Application for a Non-Material Amendment Following a Grant of Planning Permission

**Firstly; our planning application: 19/p/2245/fuh comprised of a, single storey extension which was completed and signed off by N. somerset council in June 2021, AND, the addition of dormers to an already existing loft conversion which we are planning to start in May 2024. (A building application/notice & structural drawings will be submitted by a private building control firm in due course). We wish to REMOVE CONDITION 2 and make a minor amendment to the materials and finish with 'render' to match the single storey extension, rather than wood cladding. This is obviously, the rear of the property only and matches many homes in the vicinity. (please see photos of the render to be used, and surrounding homes).

Proposed Layout

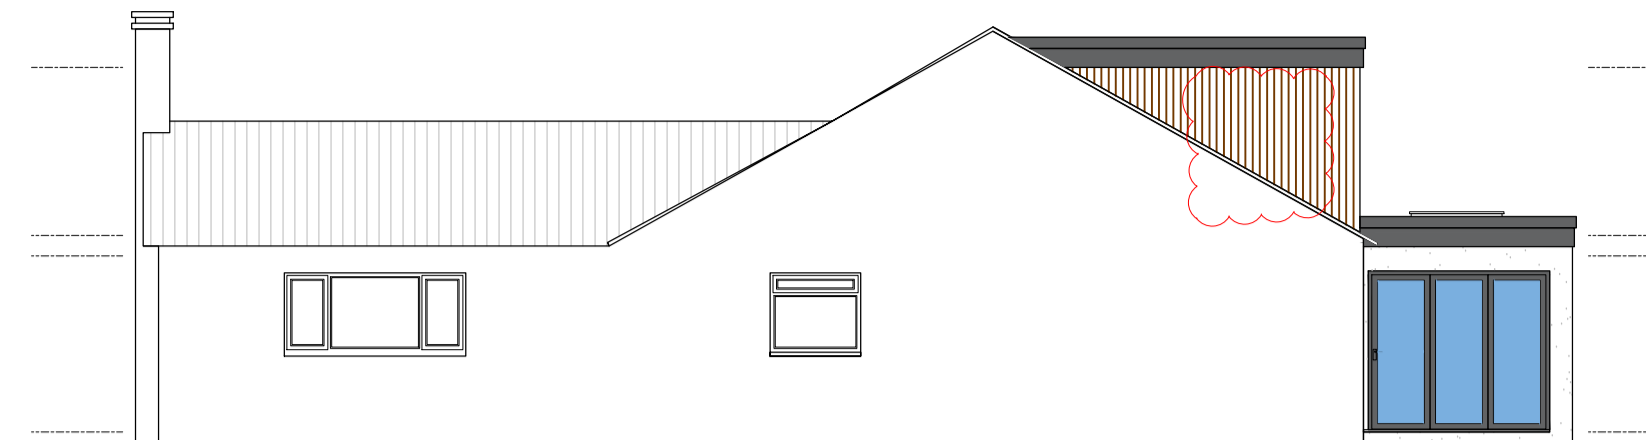
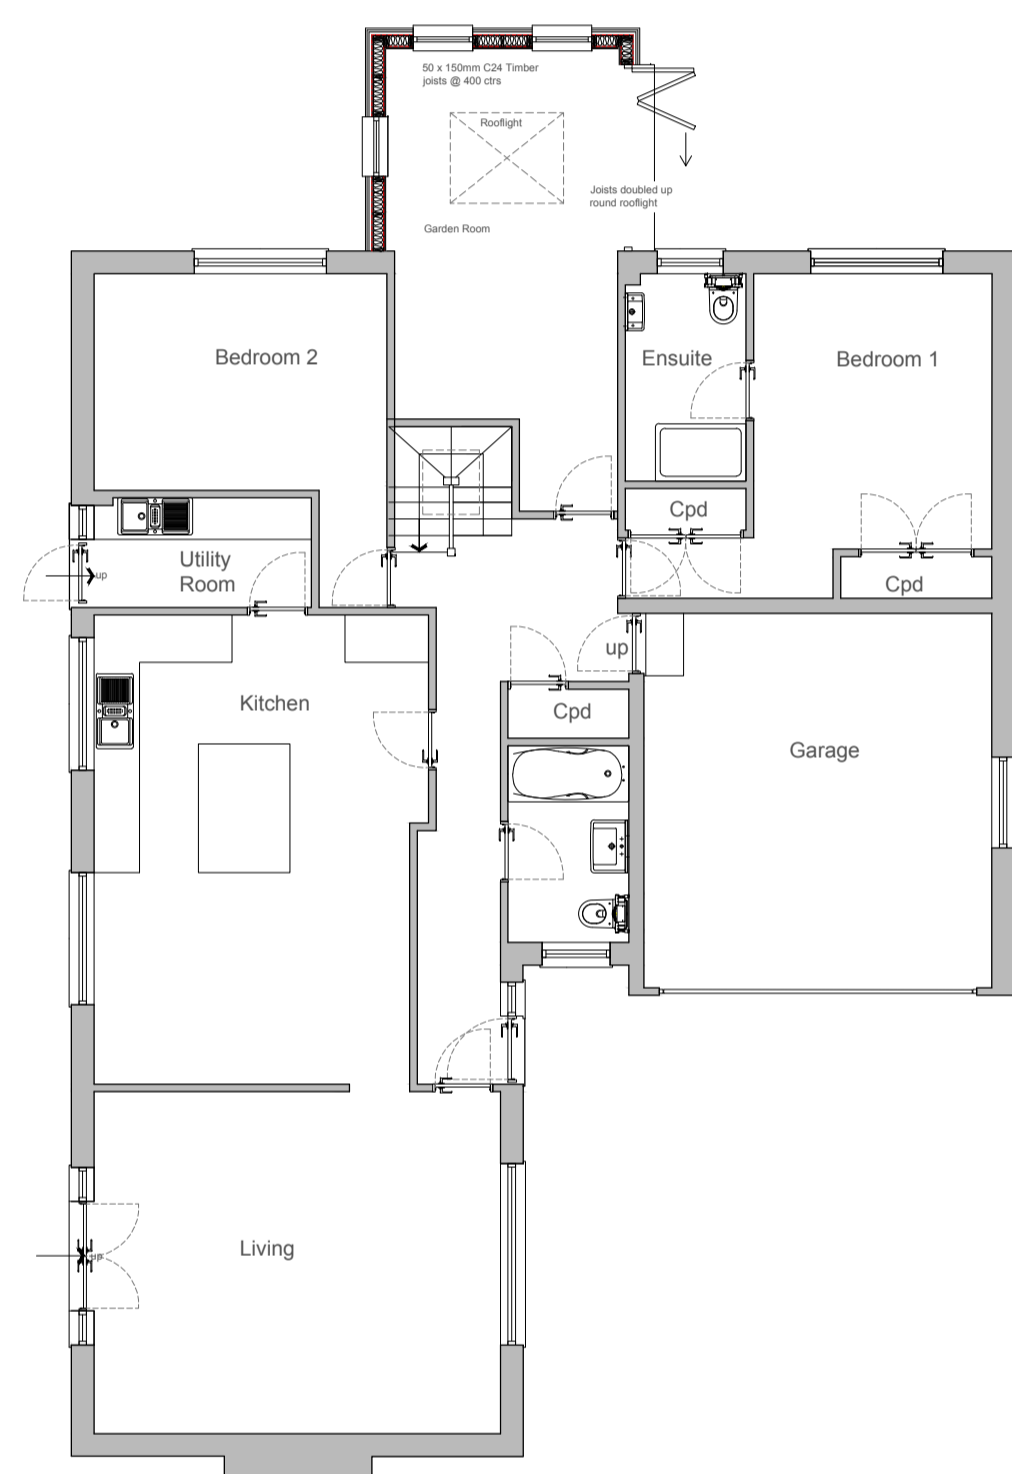
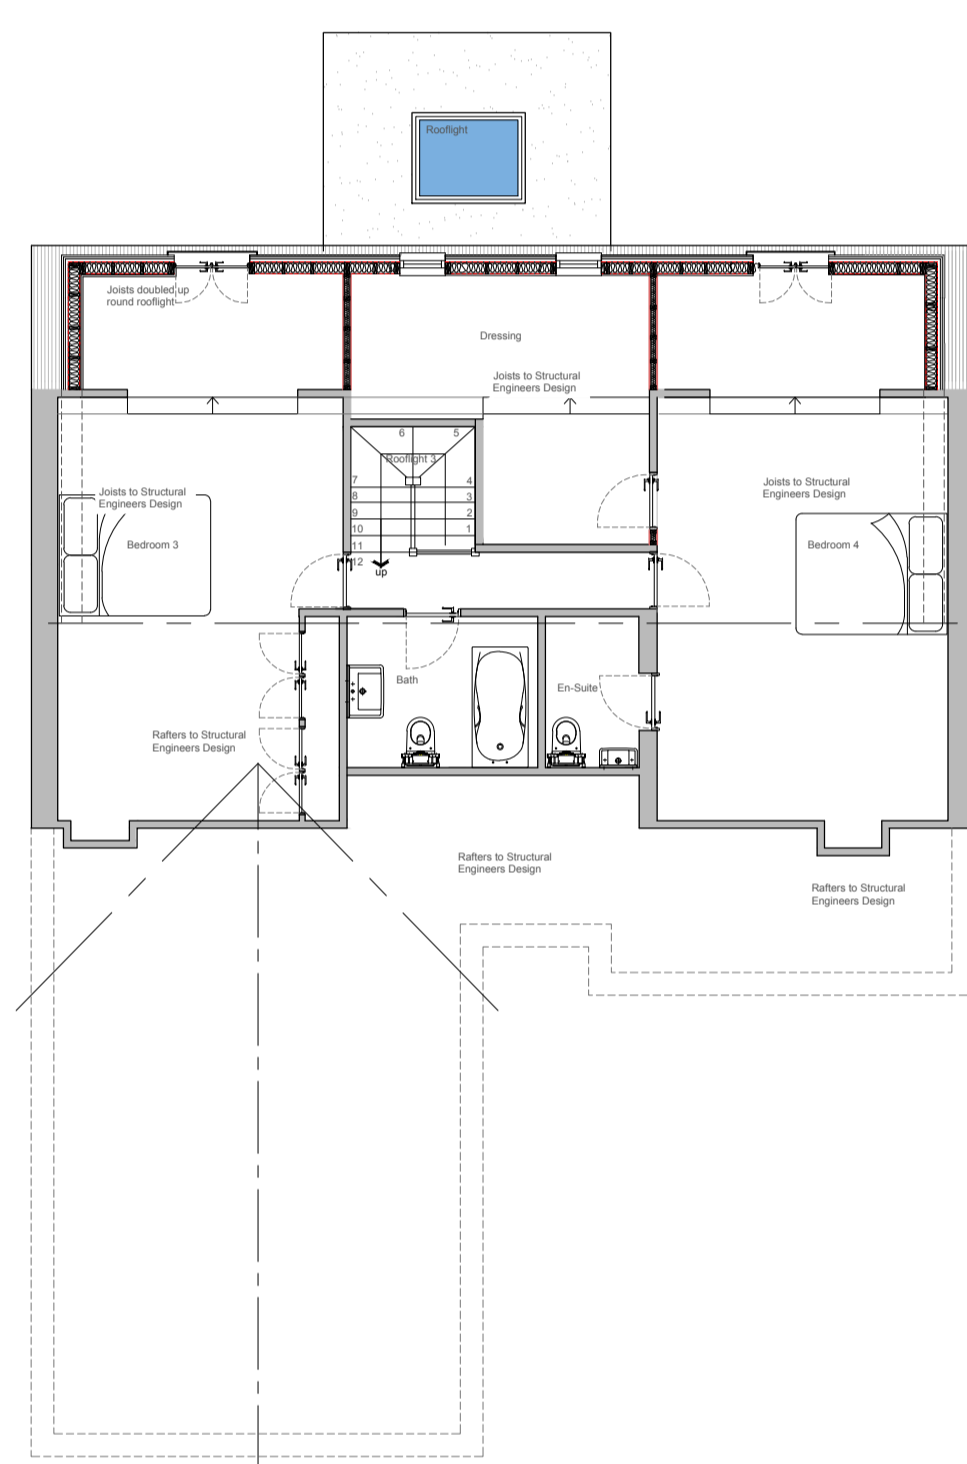
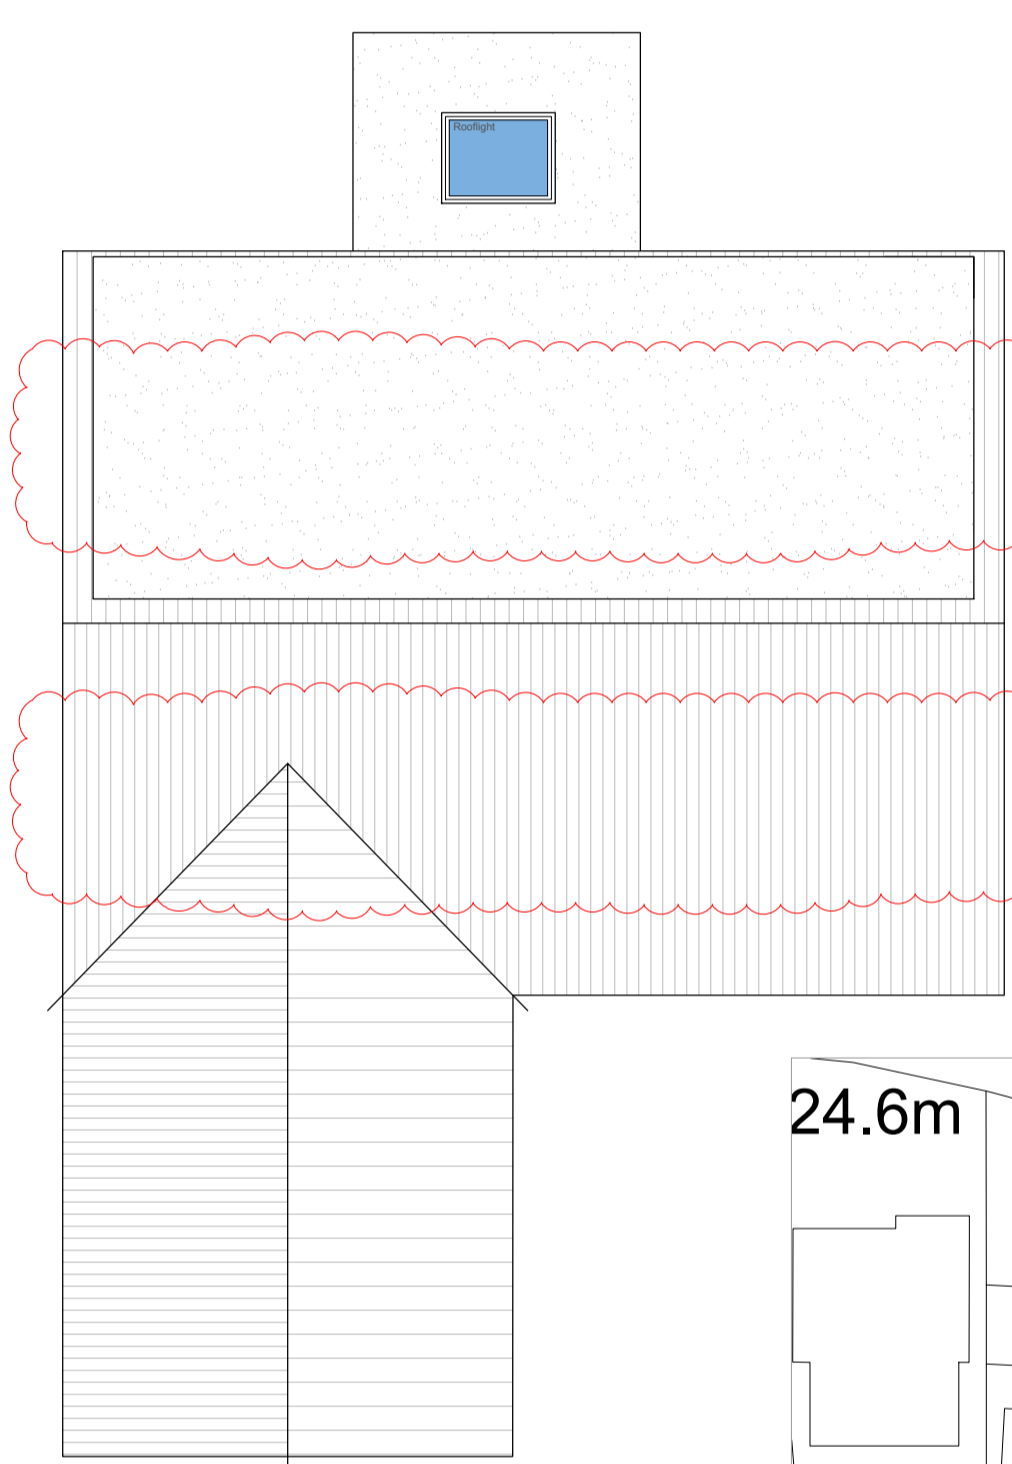
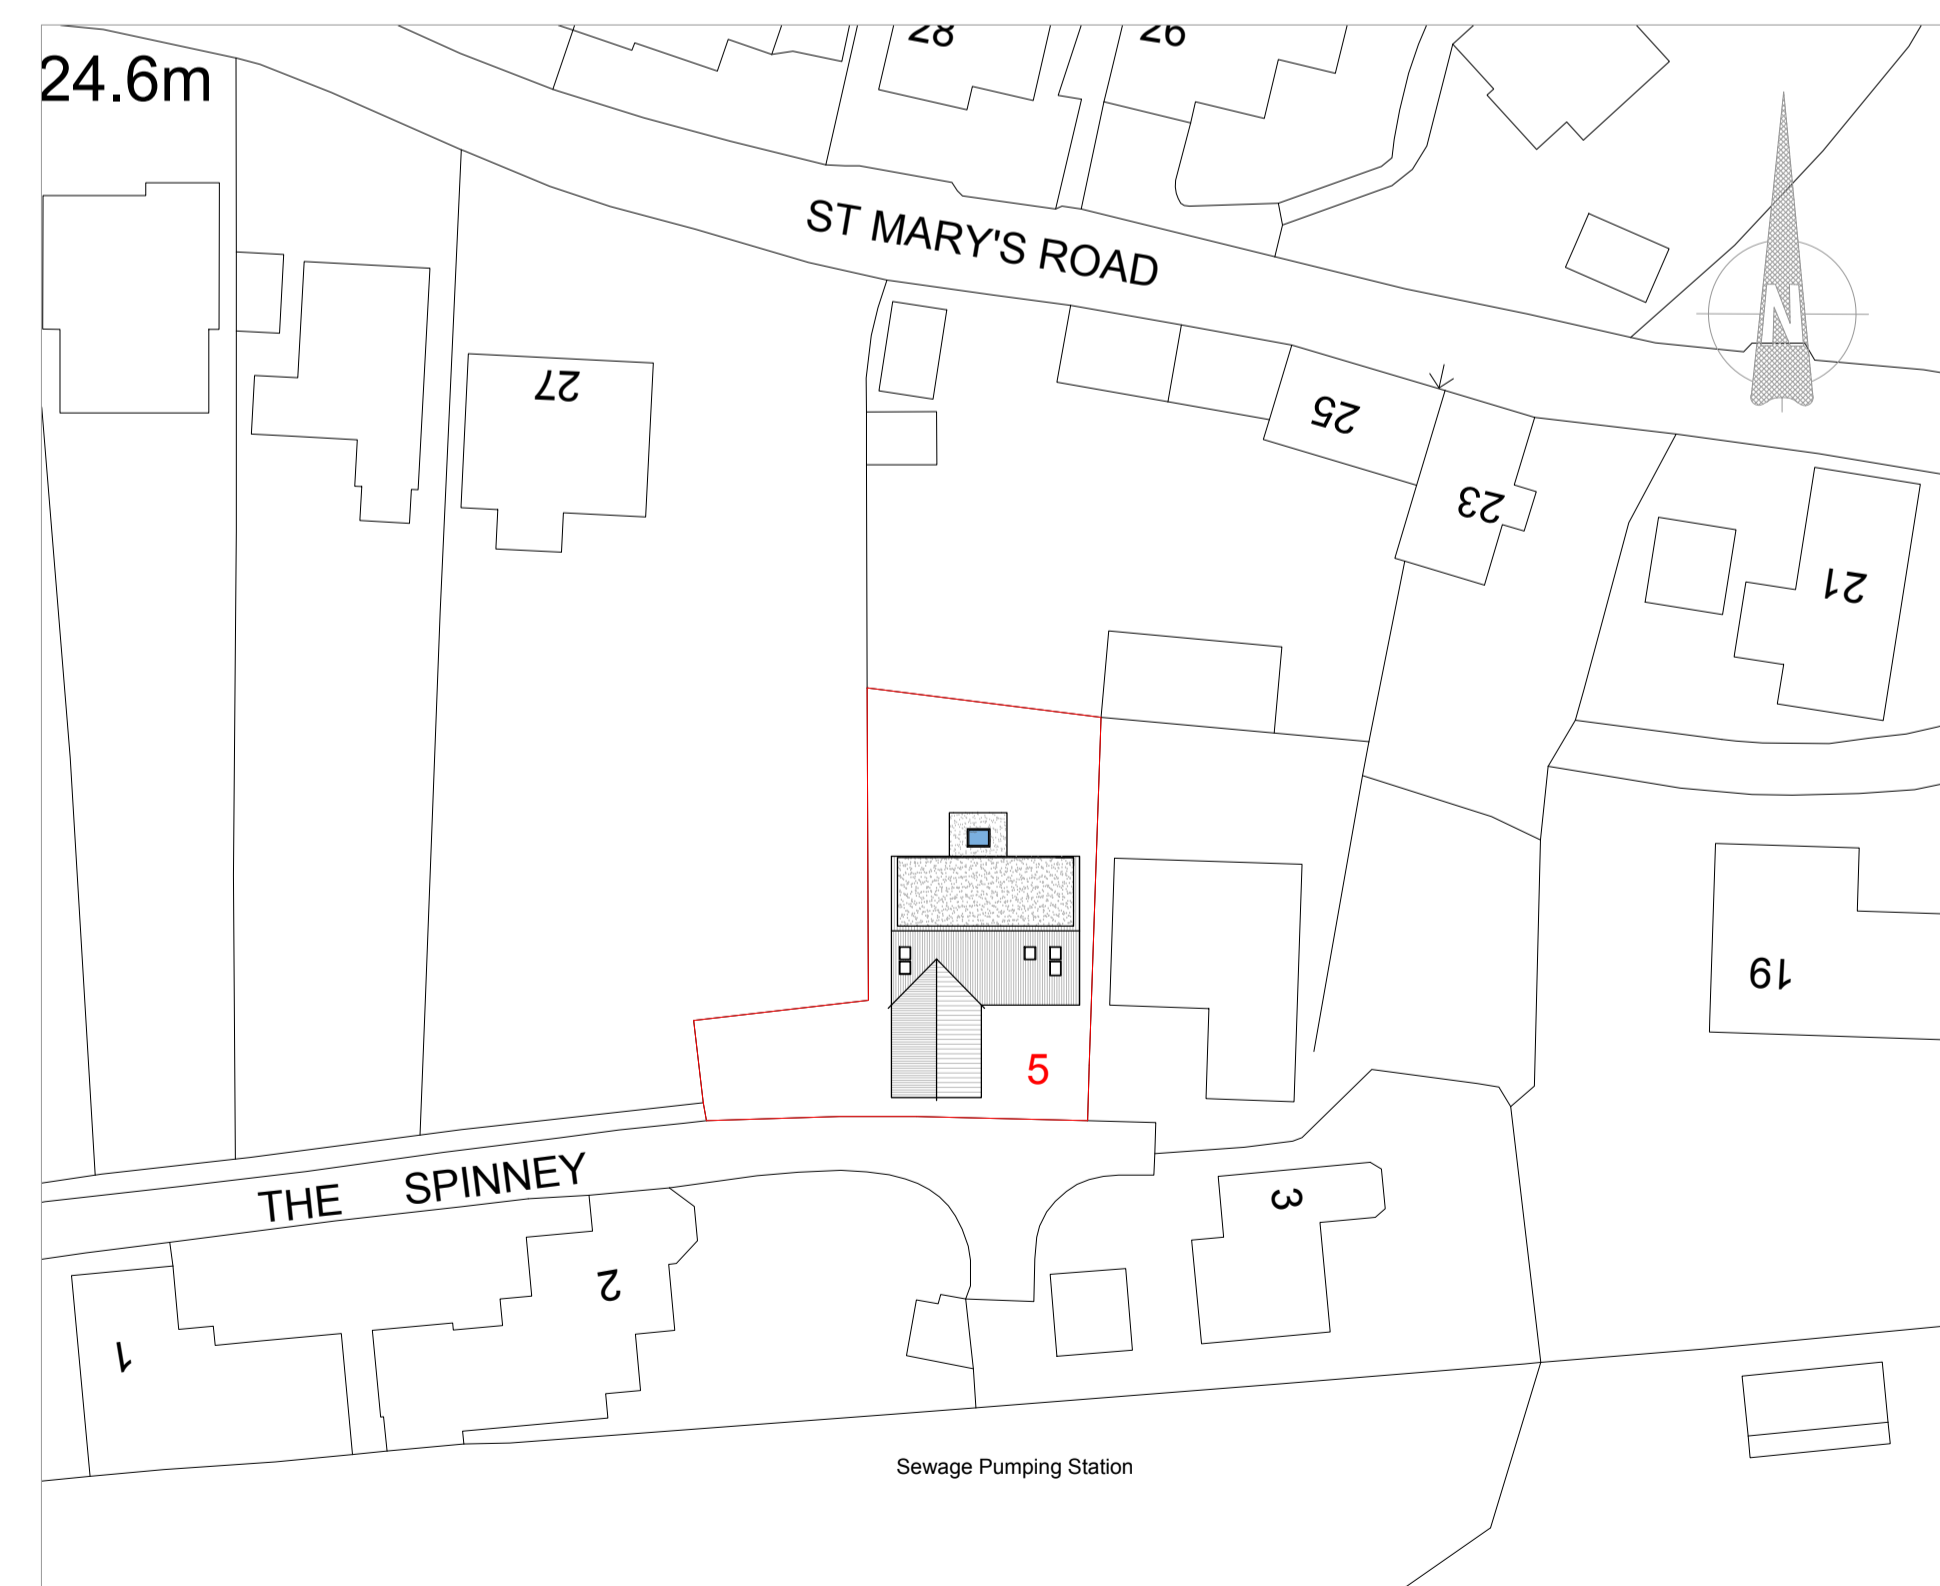
Please note that we have removed the side windows and skylights in bedroom 3 & 4 dormer extension area. The balcony doors remain in each room but at a slightly reduced size (1000mm width). The 2 windows in the newly created dressing area will be brought in slightly (300mm each side, to allow better storage).

1. Finish with Render ('Wetherby' colour H 1502-R) rather than wood cladding. This is a very natural soft grey tone.
2. Remove side windows and skylights in bedroom 3 & 4 and reduce width of balcony windows to 1000mm. One skylight will remain at the top of the stairs.
3. Bring the 2 windows in 'dressing room area' slightly closer (300mm each side)
